From: Williams, Stephen (ENV - HEM) [Stephen.Williams@lancashire.gov.uk]
Sent: 29 August 2012 13:40
To: planning
Cc: Nick Bass
Subject: FW: R.Valley - 3/2012/0738 - Land off Dale View Billington Clitheroe Lancashire BB7 9LL FAO Colin Sharpe
Attachments: Land off Dale View Billington Clitheroe Lancashire BB7 9LL doc; 40 Billington.pdf; 2012-08-29 12_0738_Proposed_plan[1].pdf

no: Existing & proposed site & location plans

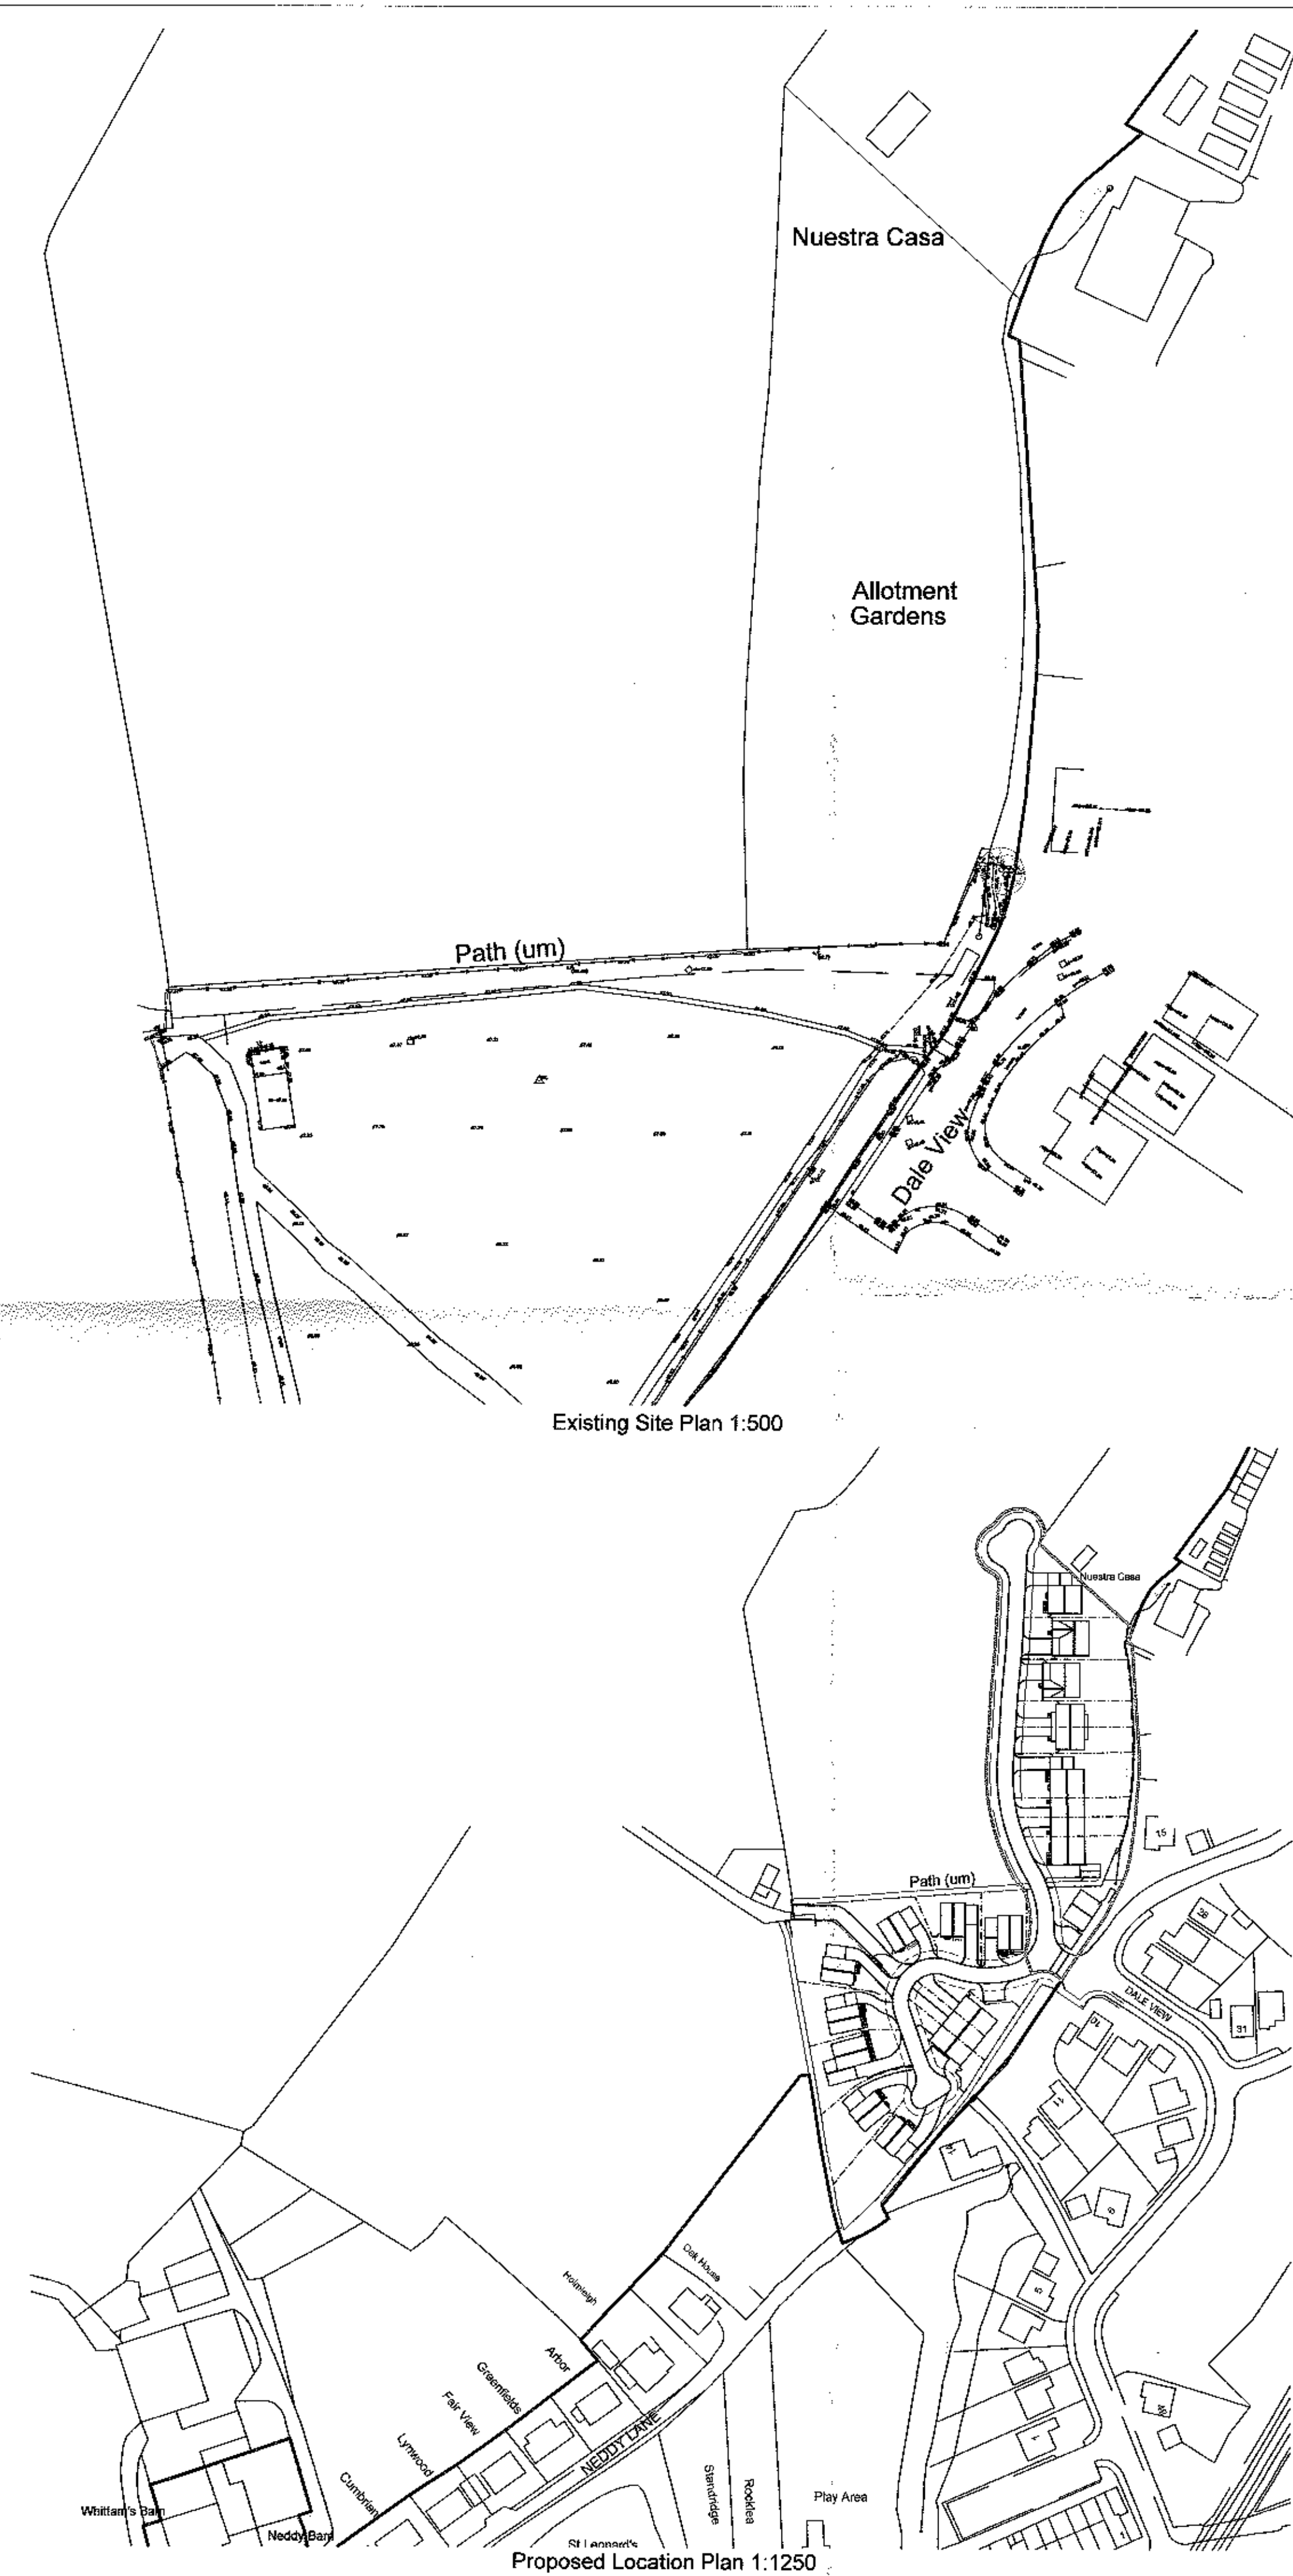
If the developer proposes to make any changes to the surfacing of the right of way they should seek guidance from Nick Bass. I note from the proposed layout plan that refers to 'Public Footpath repositioned' for Public Footpath Nos. 40 and 41. If a diversion of the Public Footpaths is required to allow the development to commence this should be completed by Ribbles Valley Borough Council under the Town and County Planning Act 1990 prior to the development starting.

I note from the attached plan that the proposed width of the public footpaths is to be 1.5 metres. The minimum acceptable width for a diverted public footpath is 2 metres and the County Council will object to a diversion order that provides an alternative width of 1.5 metres.

The public footpath must not be affected by the proposed development without a formal diversion being completed under the Town and Country Planning Act 1990. The developer should contact Lancashire County Council if a temporary closure is needed during the construction stage. A temporary closure will only be granted where the public footpath can be re-opened on its original line when the development is complete unless a permanent diversion has already been finalised.
